Application Ref:	3/2025/0970			 Ribble Valley Borough Council www.ribblevalley.gov.uk
Date Inspected:	31/10/24	Site Notice:	18/2/26	
Officer:	BT			
DELEGATED ITEM FILE REPORT:				REFUSAL

Development Description:	Retrospective planning application to continue use of single storey restaurant building, outdoor seating area, play area and vehicle parking area.
Site Address/Location:	Gazegill Organic Farm, Lower Gazegill Farm, Cross Hill Lane, Rimington, BB7 4EE.

Drawing; Site Plans

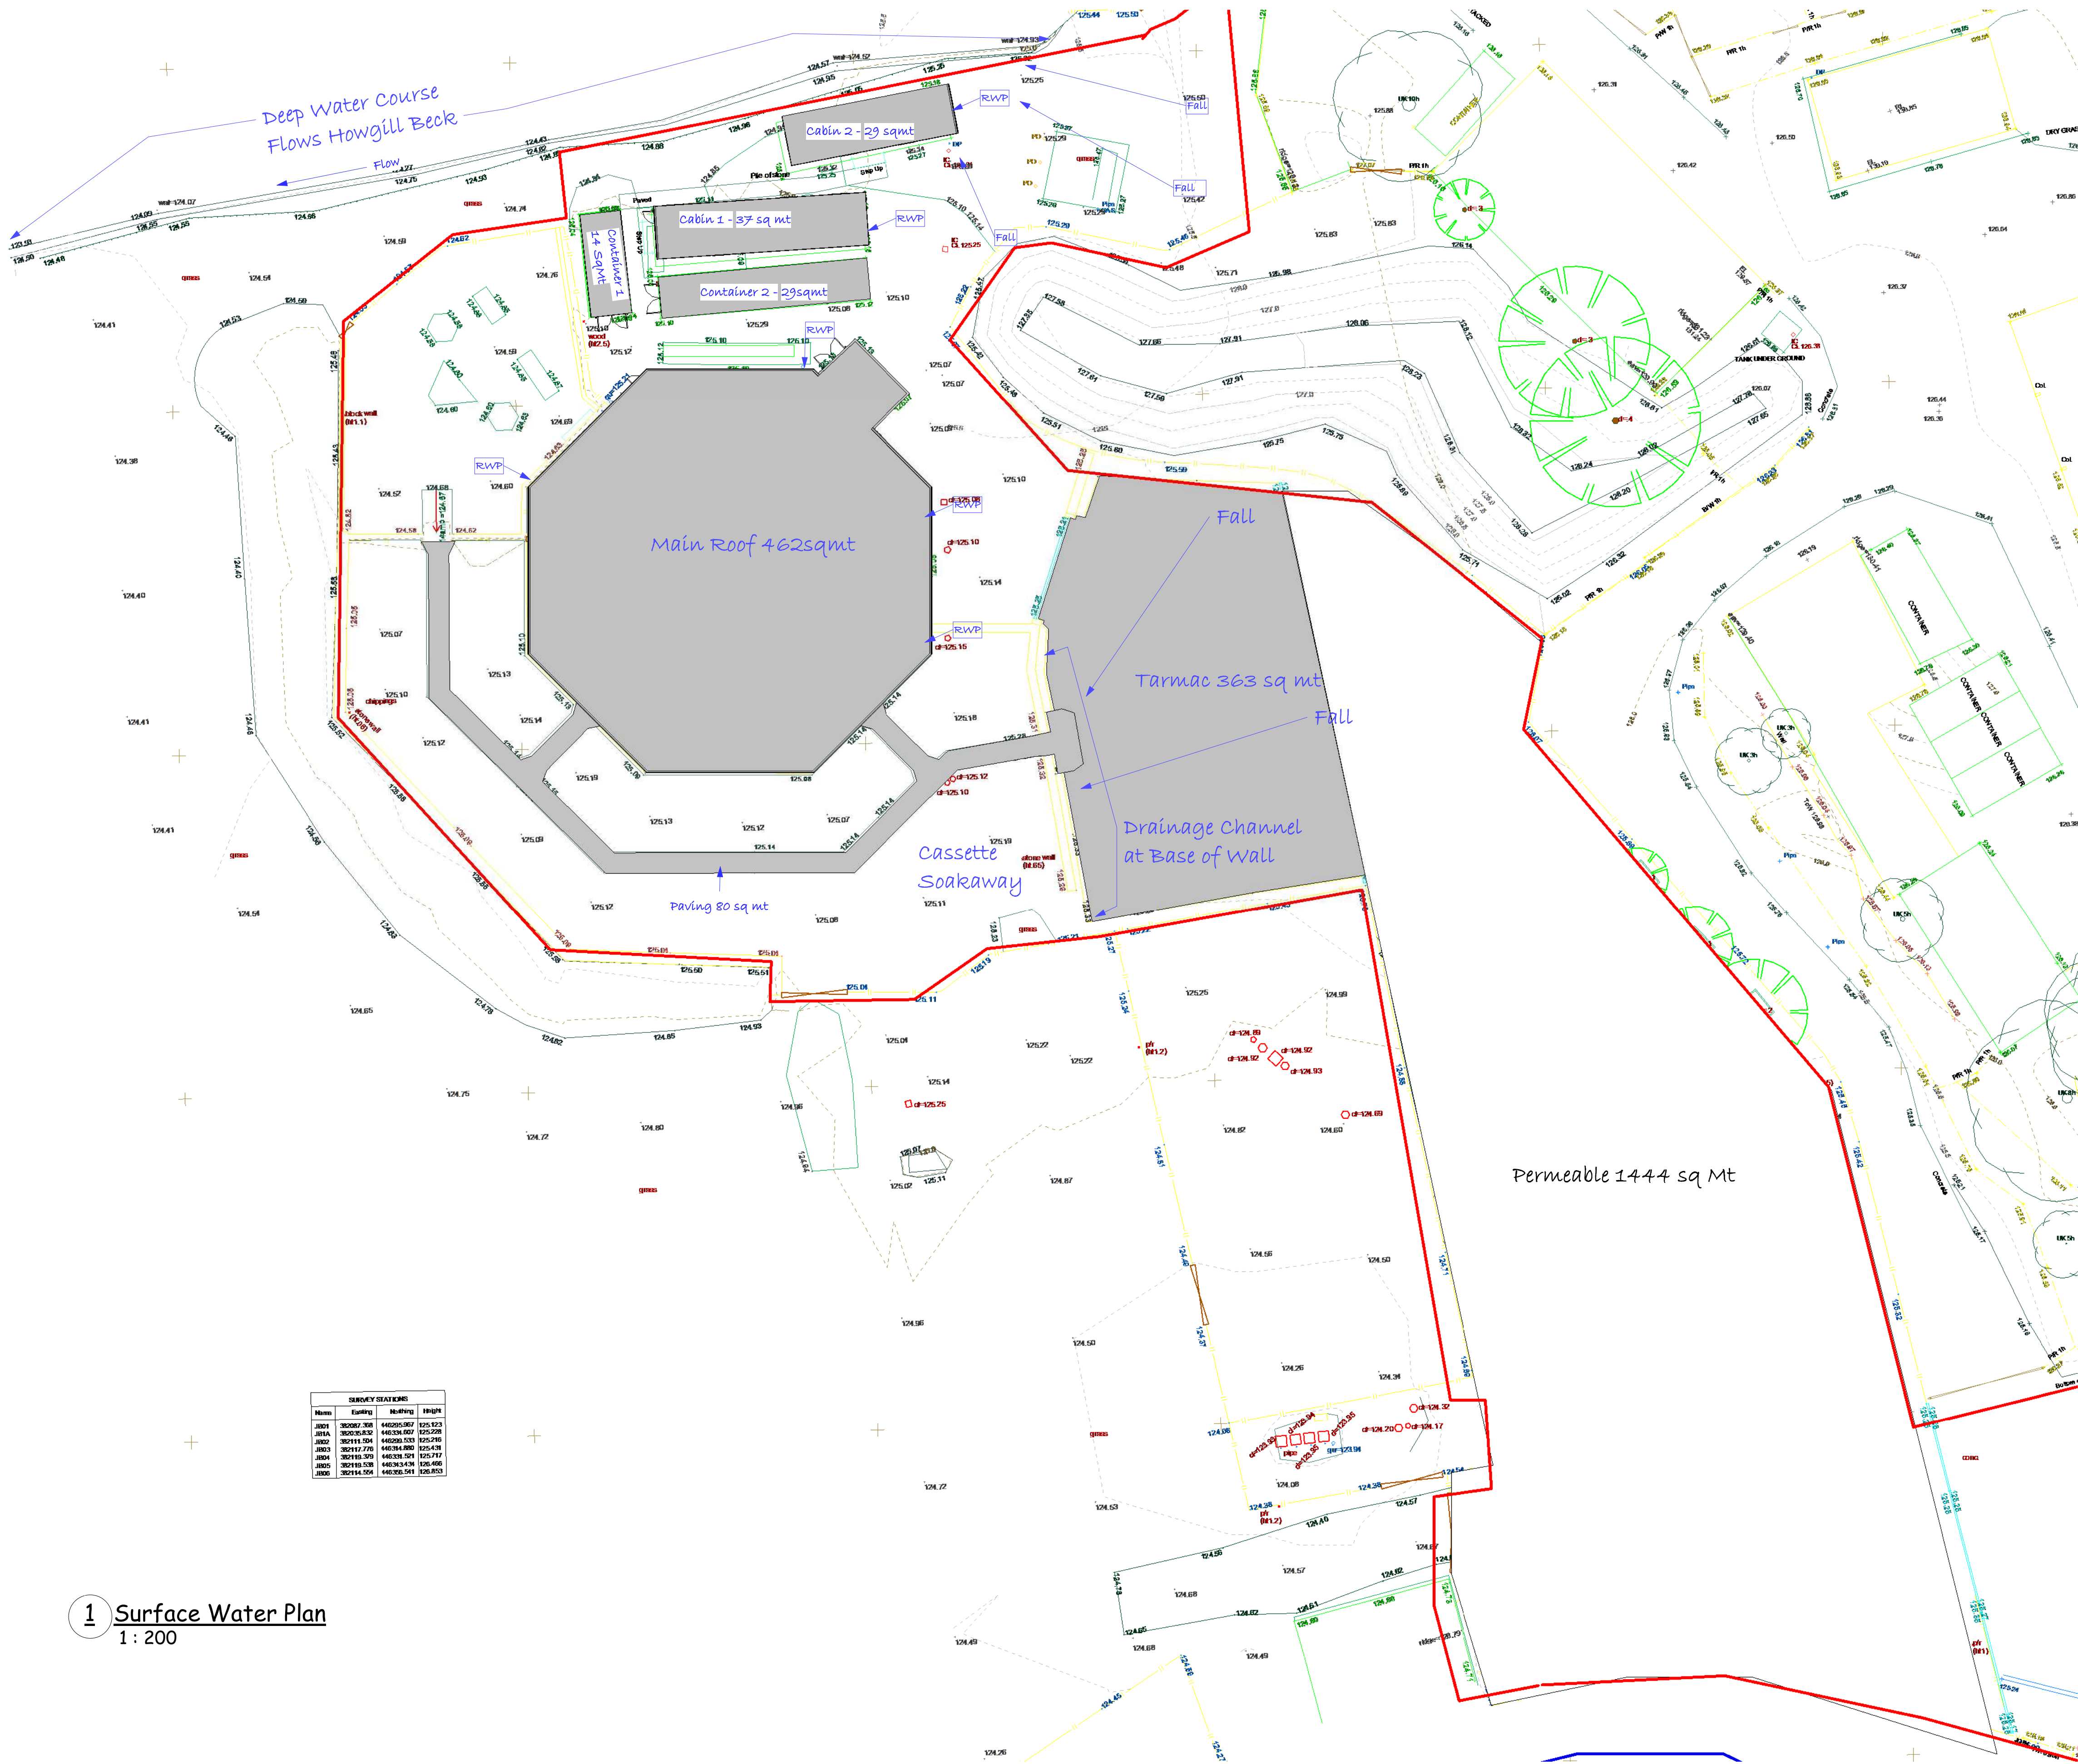
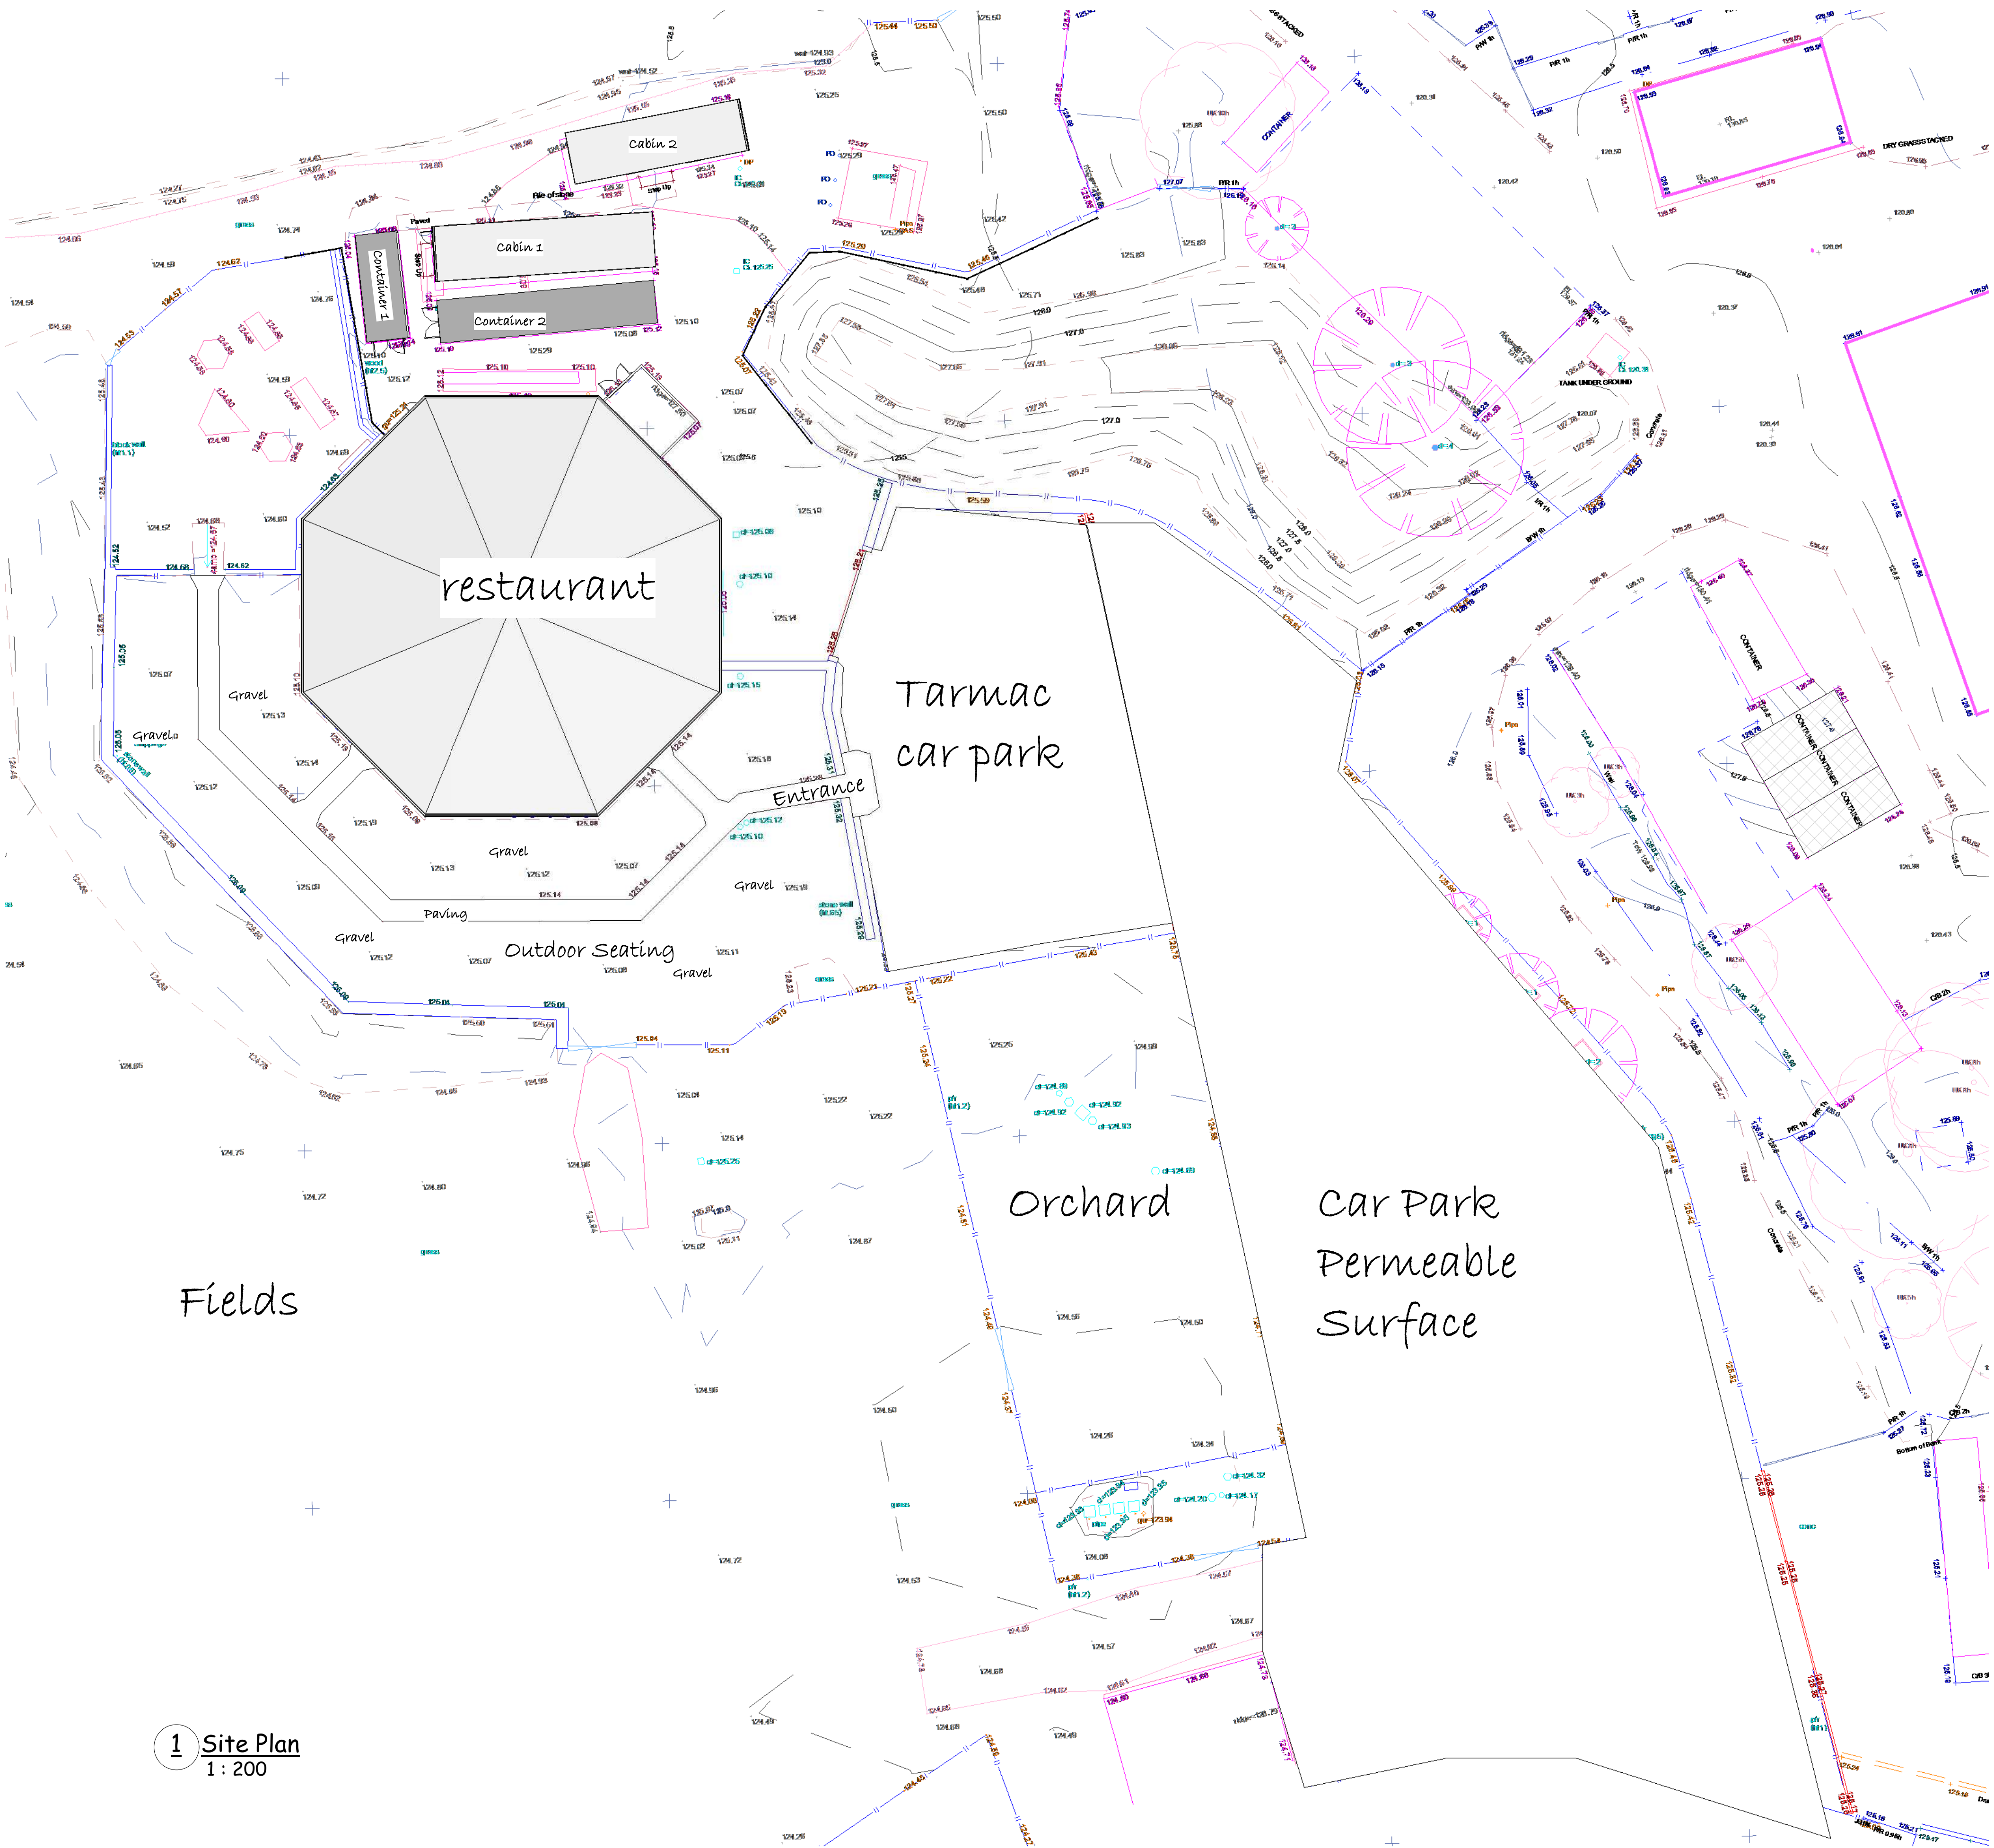
As previously conveyed, a single storey building has been constructed on site in the location of the tea room approved under previous application 3/2016/1159. This building differs from the approved tea room building with respect to its fenestration and roof profile. Furthermore, an outdoor seating area has been constructed to the South of the proposed single storey building in addition to an extension to the site's existing hardstanding area to serve as an extended parking area for the restaurant. Four single storey cabin buildings have also been placed within the site to the North of the restaurant building.

Notwithstanding the deviation from the development approved under application 3/2016/1159, the constructed single storey building otherwise retains the footprint of the originally approved building and whilst its elevational treatments contain a greater quantity of glazing relative to the previously approved development, the elevations of the building nonetheless consist of an oak based frame with timber shingles as was approved for the original tea room building. Furthermore, the roof profile of the unauthorised building retains the same octagonal design approved for the original building, albeit with a lower roof pitch carrying slightly less visual impact. As such, the design and external appearance of the proposed building largely reflects the development approved under previous application 3/2016/1159. Furthermore, whilst the outdoor seating area and extended vehicle parking area amount to a further deviation from the operational development approved under application 3/2016/1159, these areas nonetheless cohesively adjoin with the proposed building from a visual perspective and collectively occupy roughly the same area of space as the car park area originally approved for the tea room. Furthermore, the cabin buildings within the site are modestly sized structures with regards to their height and footprint and as such are read as ancillary structures within the context of the restaurant building and site as a whole.

Drawing; Dancer Lane Key

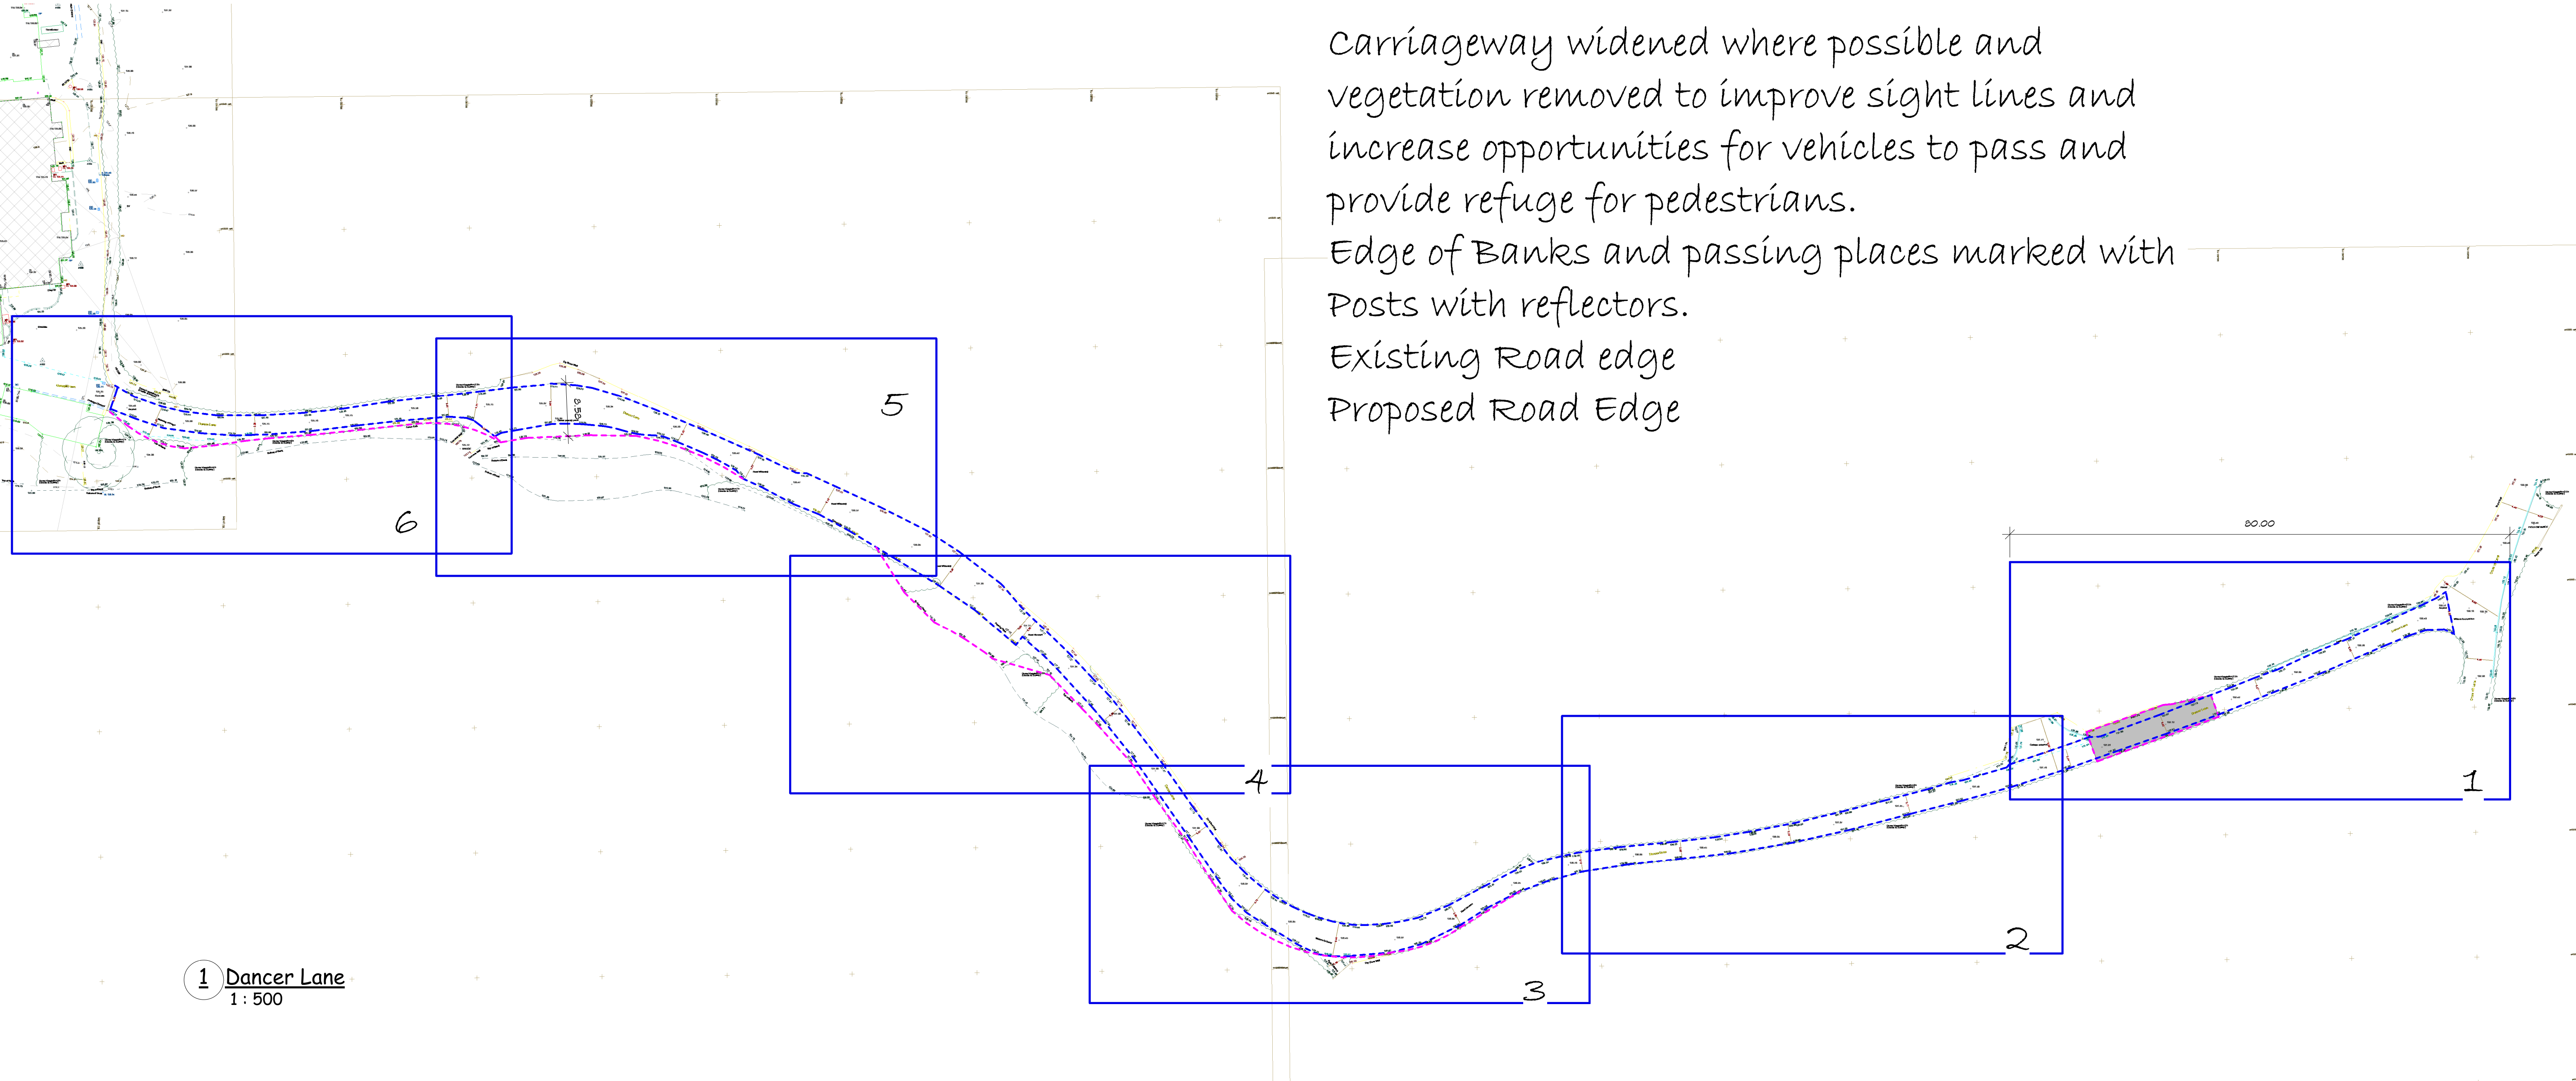
In this instance, the proposal seeks to make works of improvement to the site's access track (Dancer Lane / PROW FP0336017) which include the widening of the access track, introduction of passing places and clearing of vegetation, all of which has been supported by the Local Highways Authority.

Notwithstanding this, Dancer Lane does not form the basis of land within the application site or the applicant's ownership therefore the proposed highway mitigation measures cannot be secured by way of a condition. As such, there is no reasonable mechanism to resolve the concerns raised in the initial response from the Local Highways Authority (which were also raised under previous applications 3/2016/1159, 3/2018/0700 and 3/2024/0213) with regards to potential two way vehicle conflicts and harm to pedestrian users of the access track.

In addition, the proposed development has led to the intensification of use of Dancer Lane which lacks the adequate width and has a lack of passing facilities, lighting and footways deemed safe and suitable for such a proposal. Necessary highway improvements to Dancer Lane cannot be secured due to land ownership constraints. The development is therefore in conflict with the aims and objectives of Paragraph 115 (b) of the NPPF and Policy DMG1 of the Core Strategy.
